Subject: Lowesdale Breeder Farm – Additional matters for submissions report

Further to the Department of Planning, Housing and Infrastructure's correspondence dated 6 July 2026 regarding the State Significant Development (SSD) application for the Lowesdale Breeder Farm (SSD-936497101), the Department has identified additional matters that require further consideration.

ATTACHMENT 1

The Department's comments on the Environmental Impact Statement (EIS)

ONE TREE LANE - CONCEPTUAL PLAN

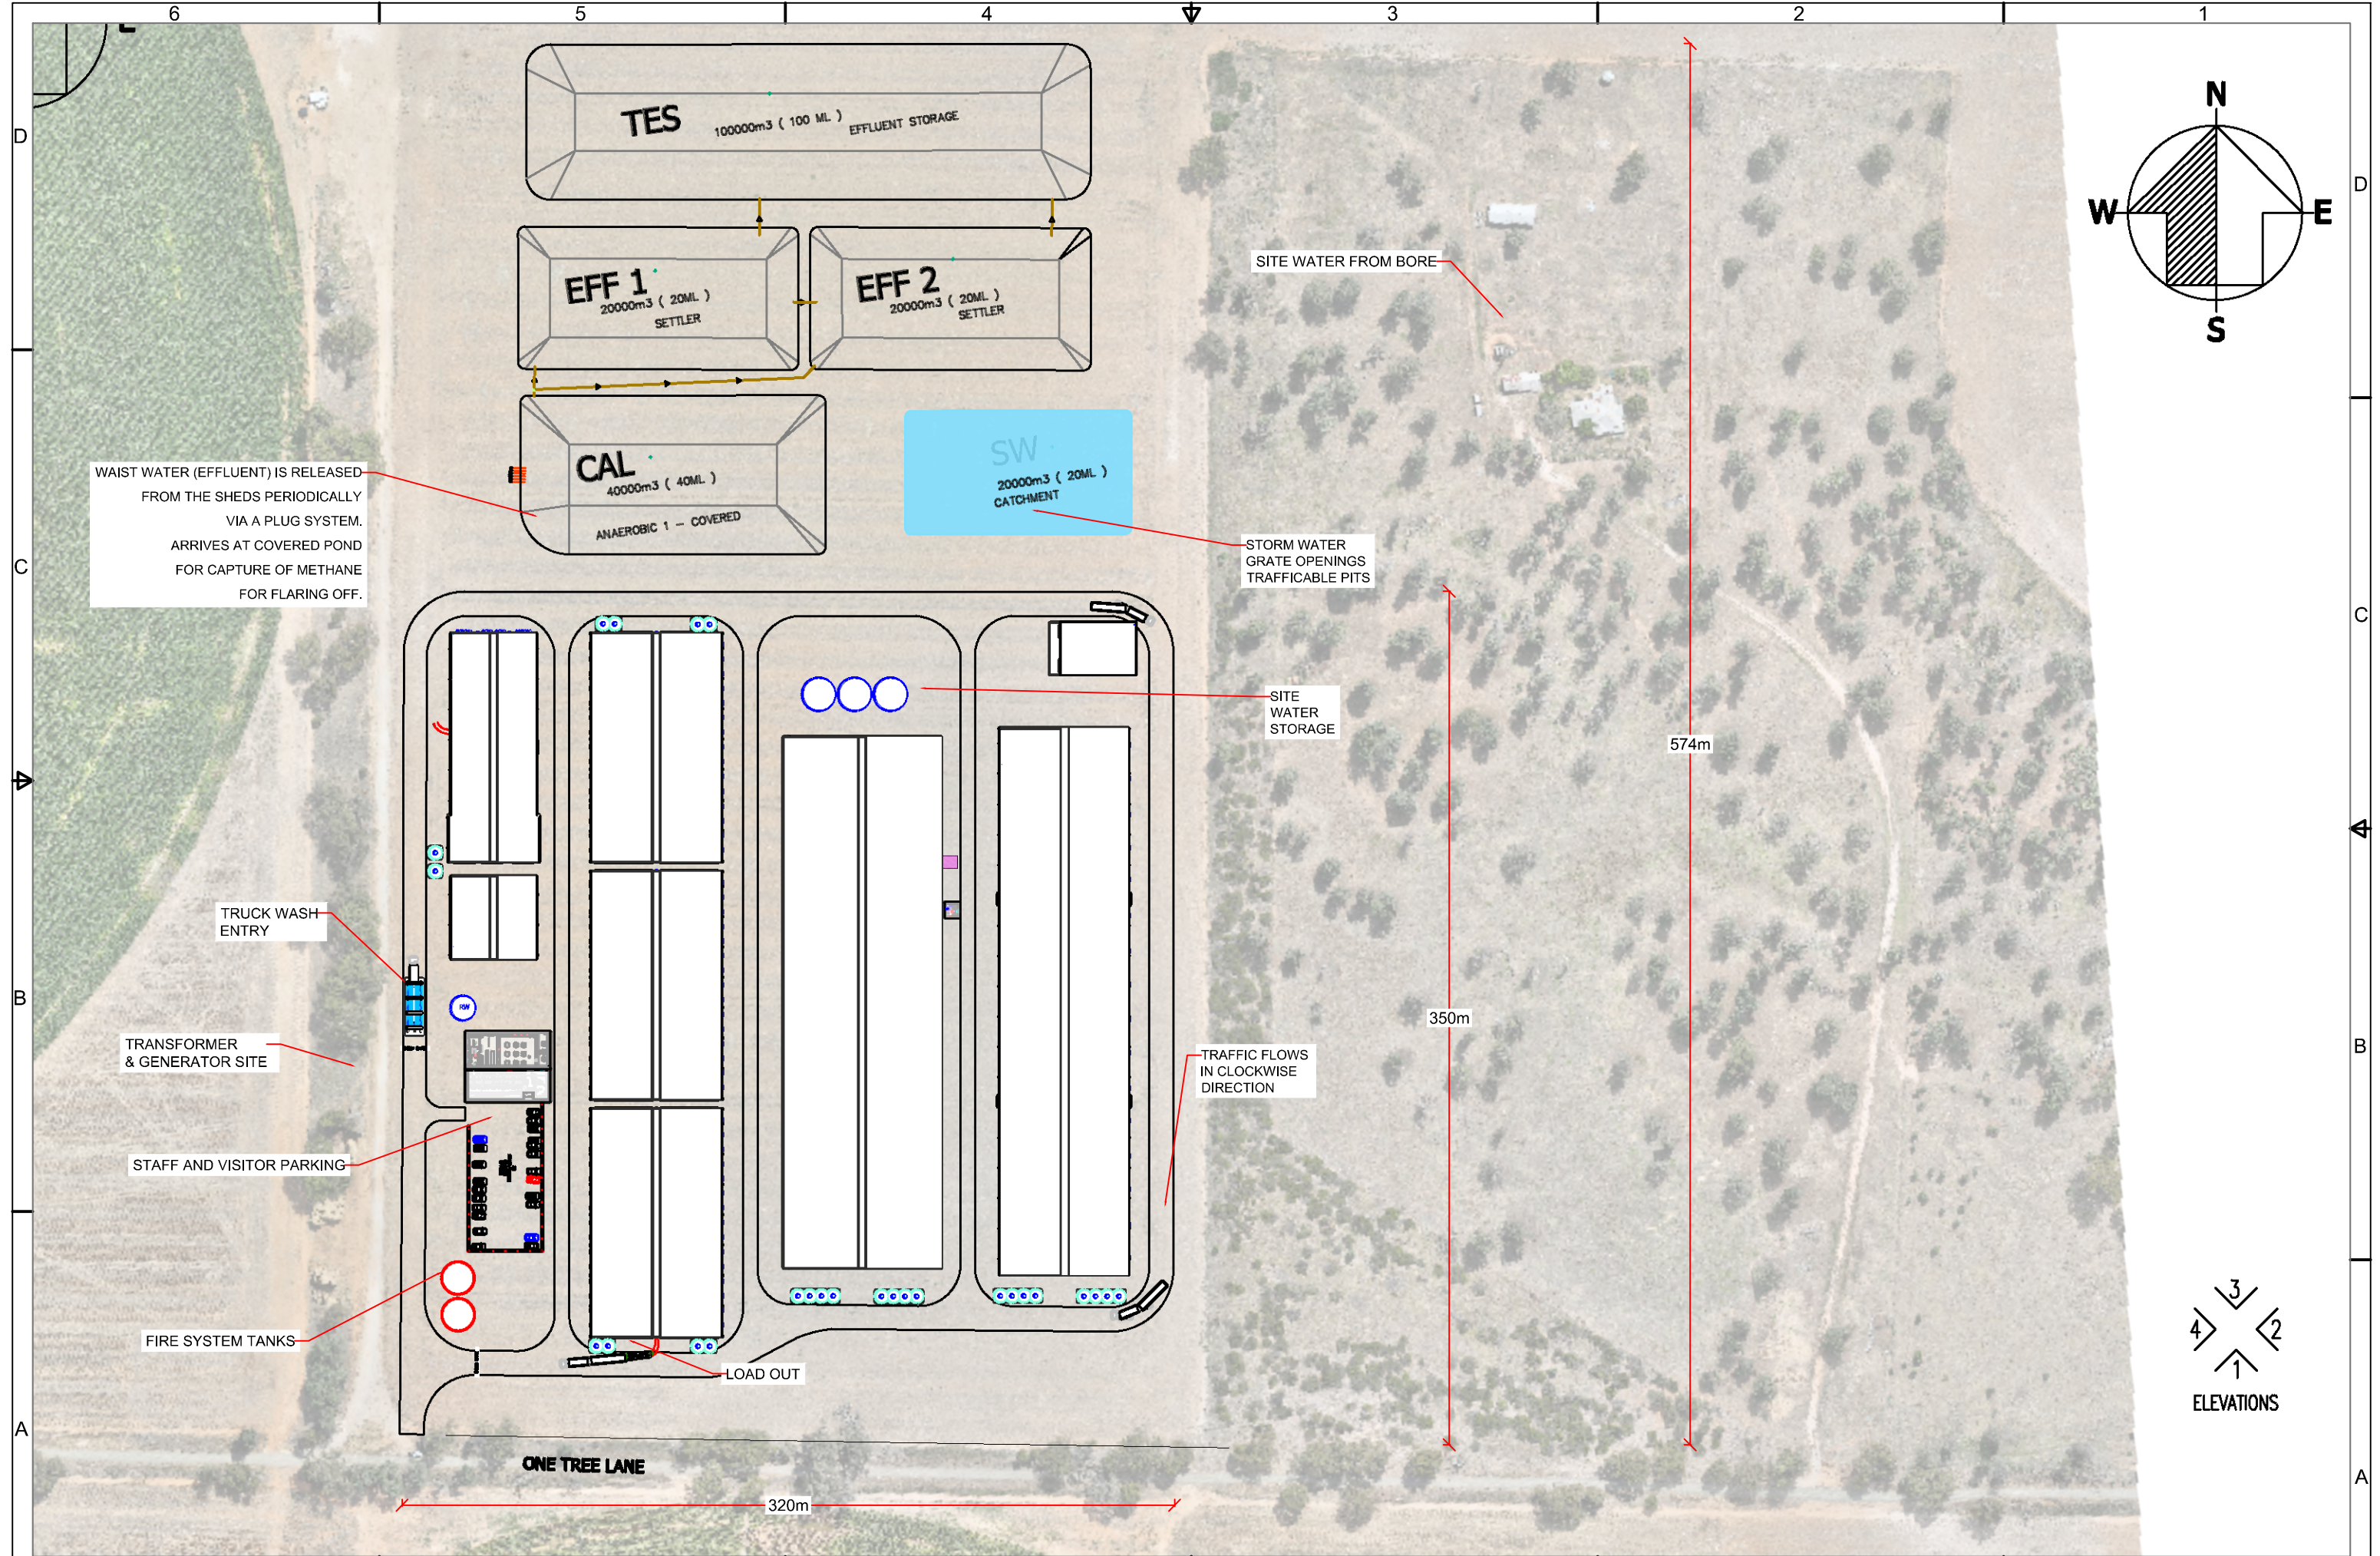
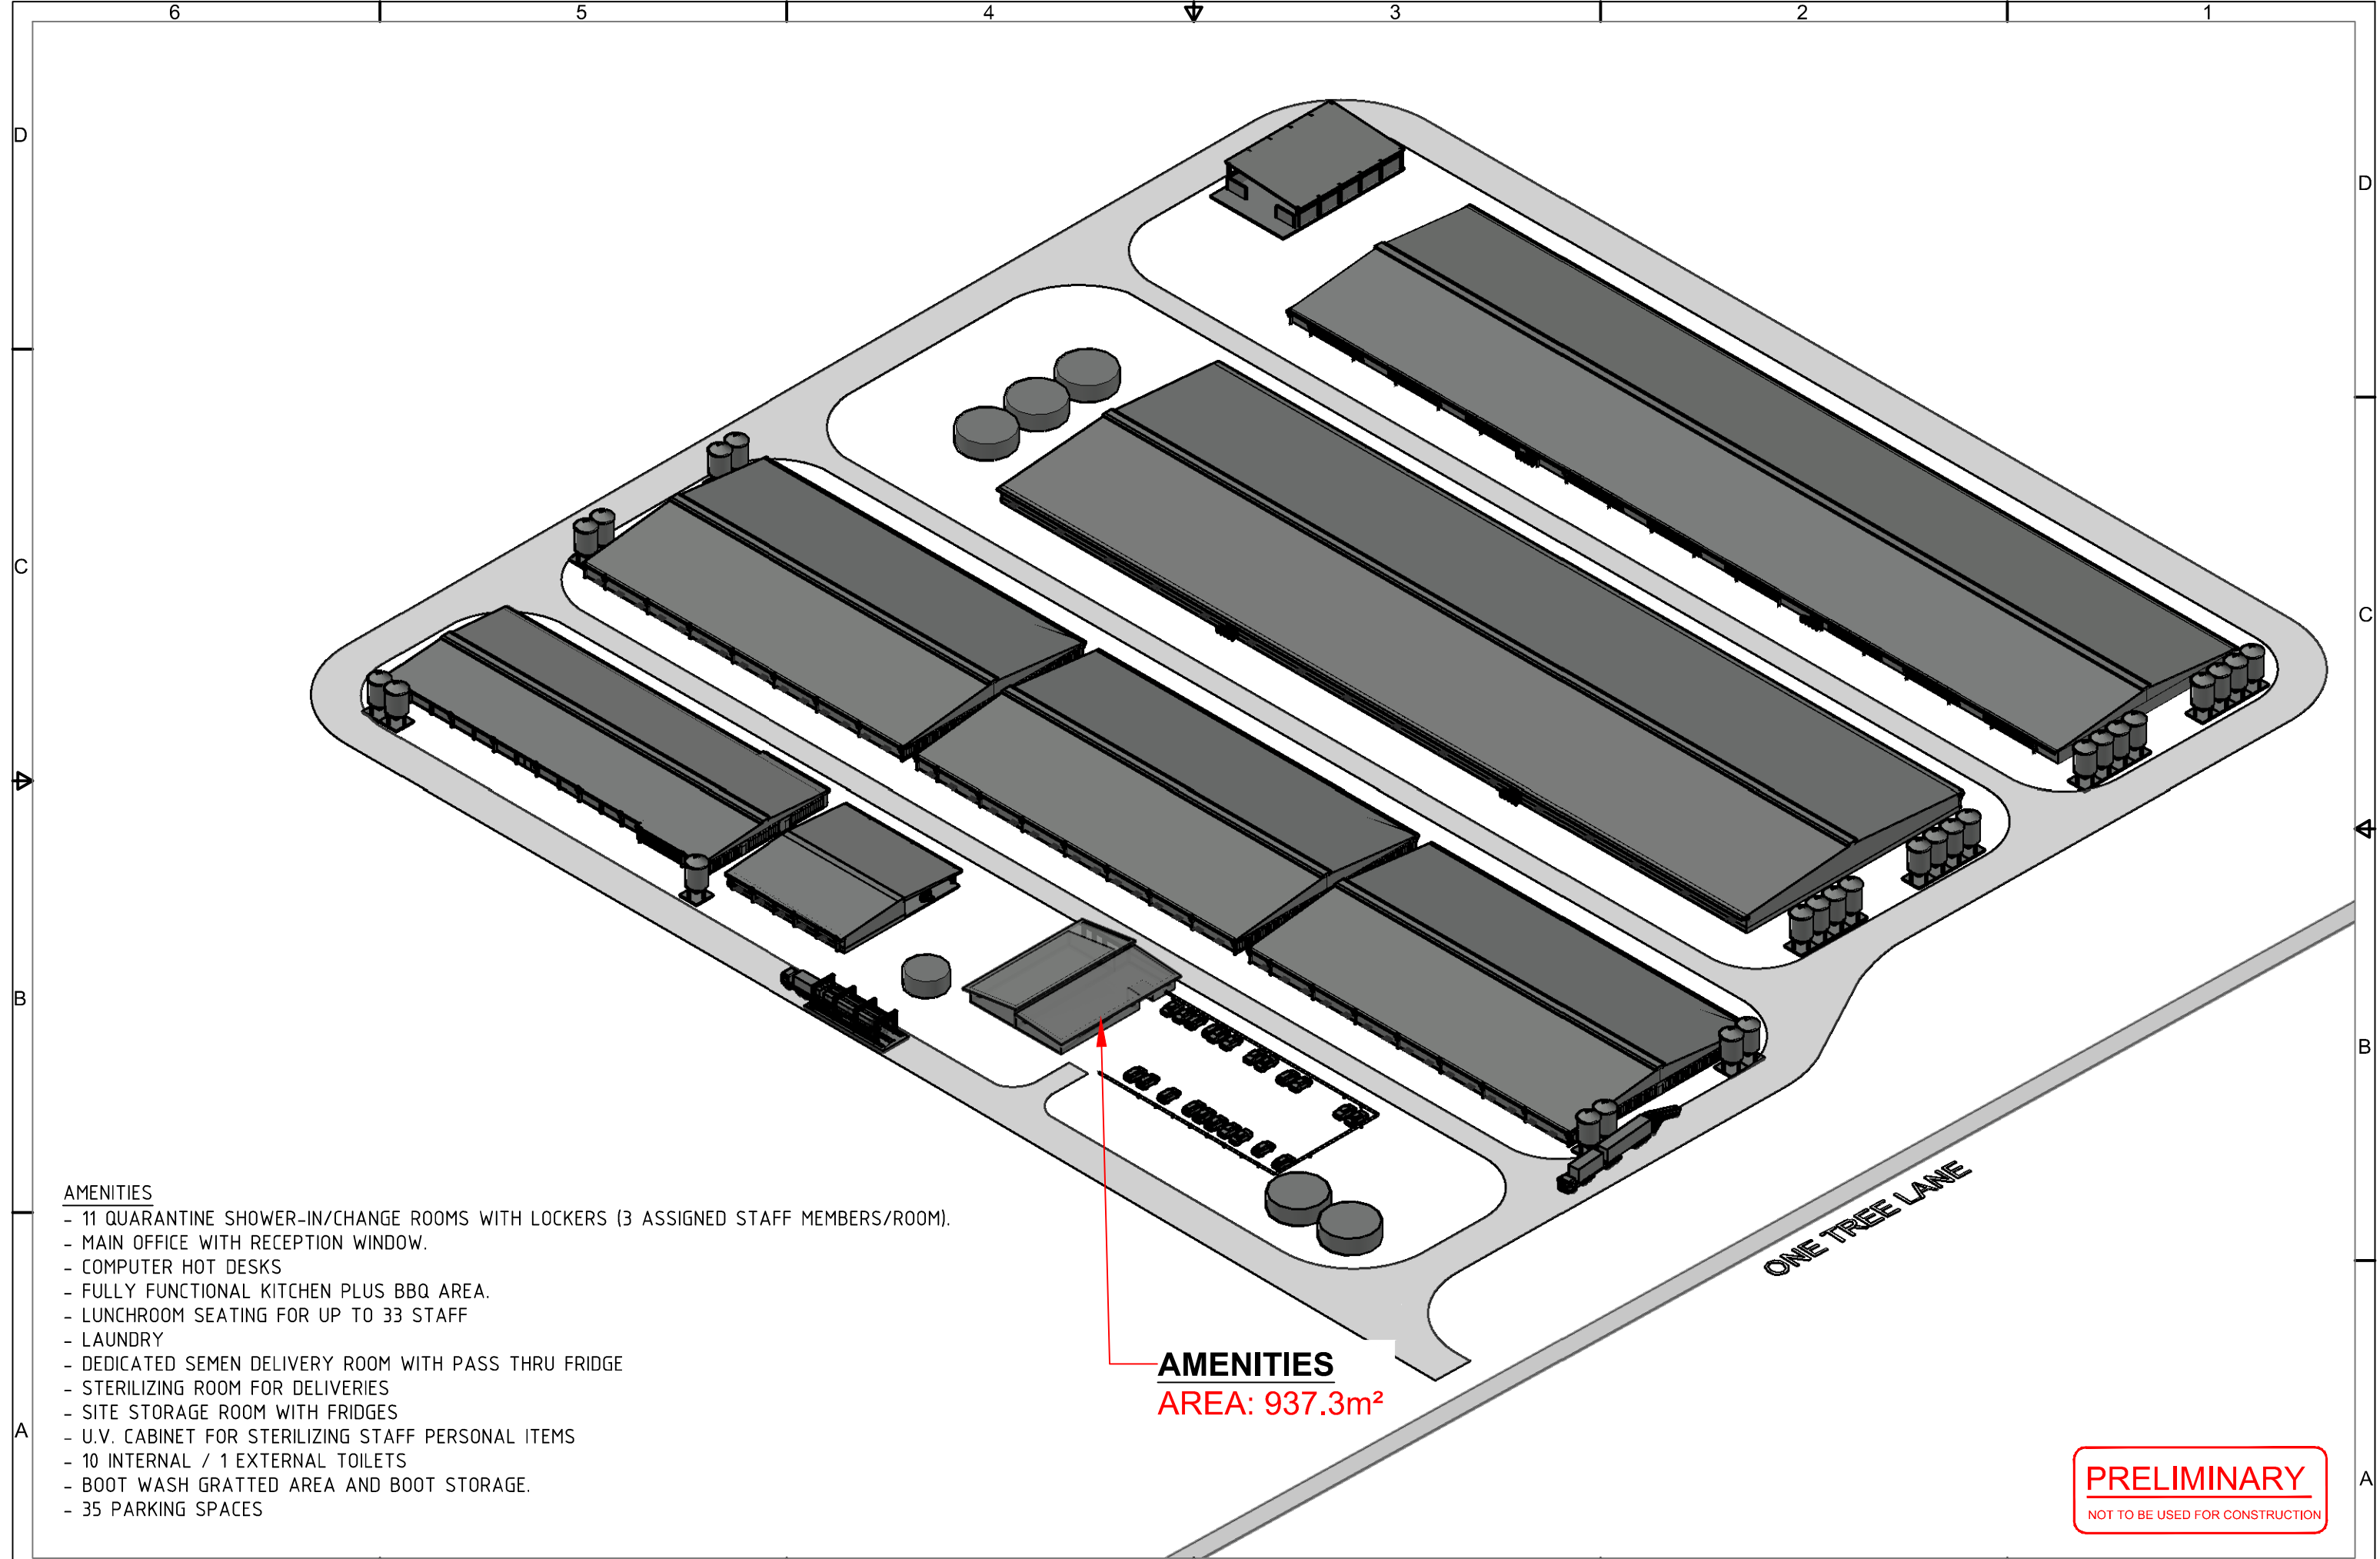
8. Please verify that the traffic volumes, vehicle types, operating hours, and future traffic scenarios used in the Traffic Impact Assessment are representative of the proposed operations and align with the traffic assumptions used in the Noise and Vibration Impact Assessment.
9. Page 104 of the EIS states that swept path analysis identified minor clipping on the south-eastern internal circulation road and interaction with vegetation near the site access. Please demonstrate that B-Double vehicles can safely manoeuvre throughout the site.

COMPOSTING
AREA: 616.5m²

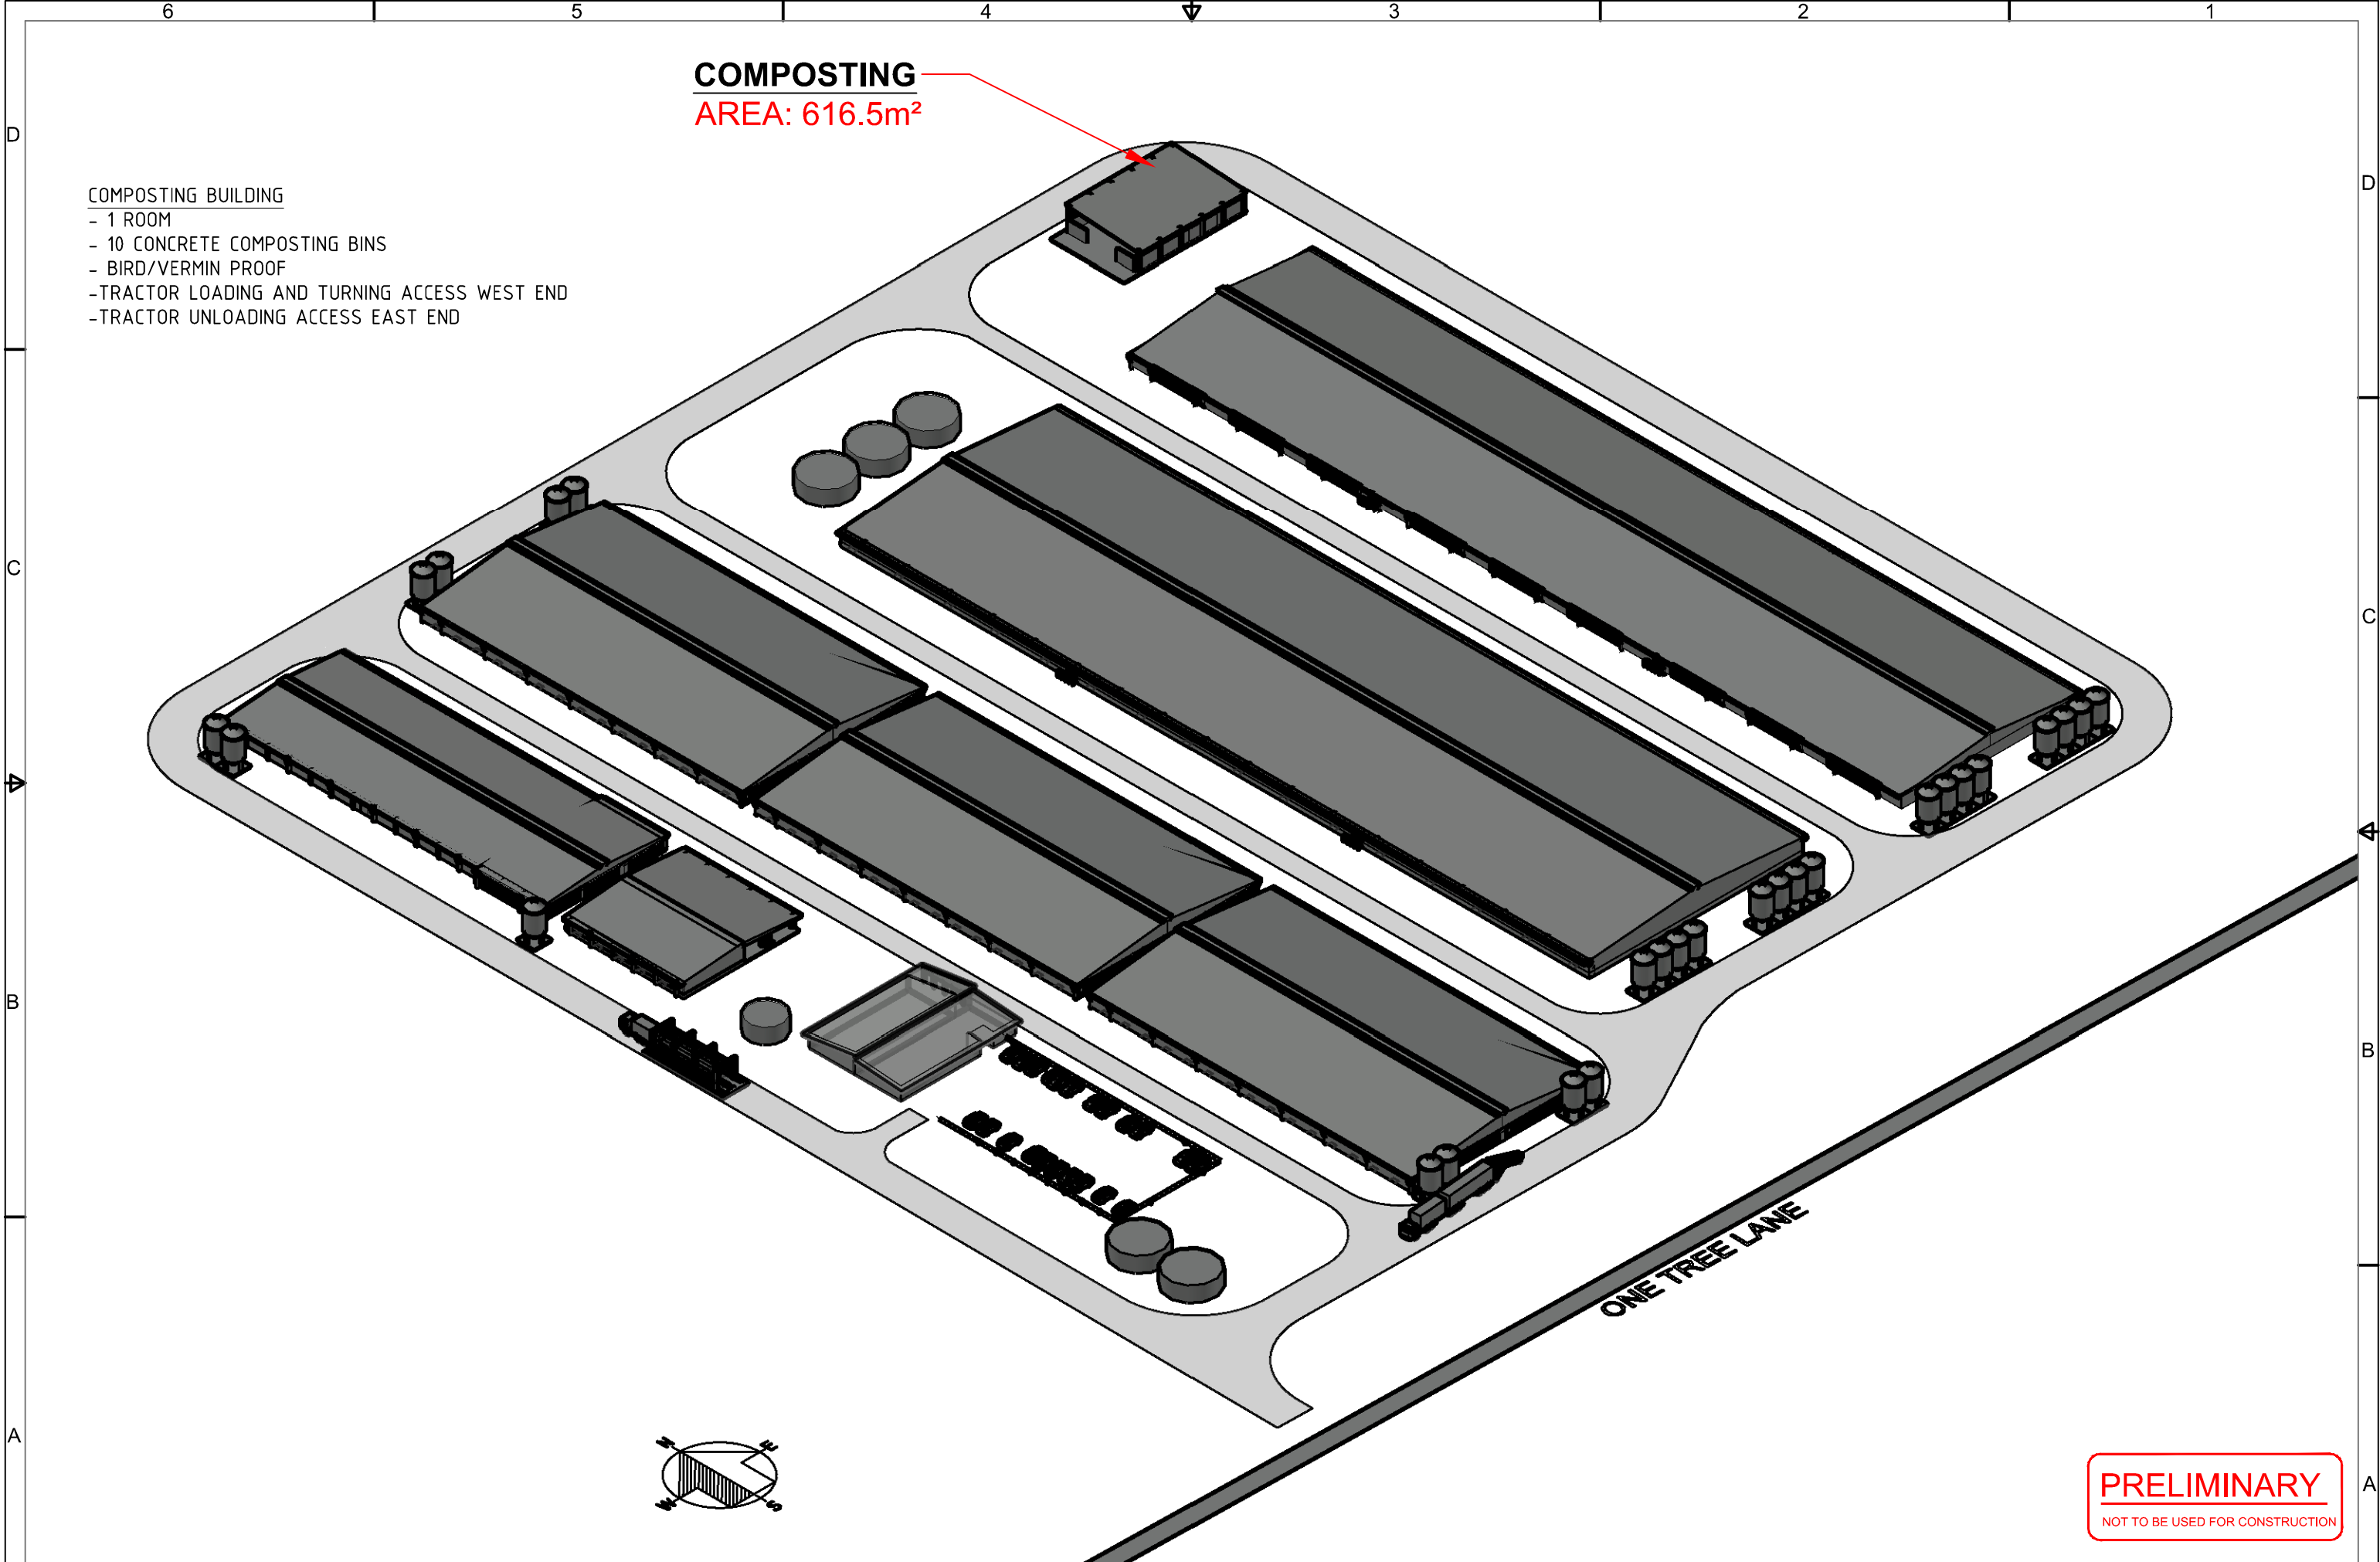
10. Provide further information regarding compost waste management, including annual compost waste volumes and if stockpiling is proposed.
11. Provide further information regarding site waste sources and volumes, including the location of the site's waste/bin room(s), and confirm proposed waste collection processes.
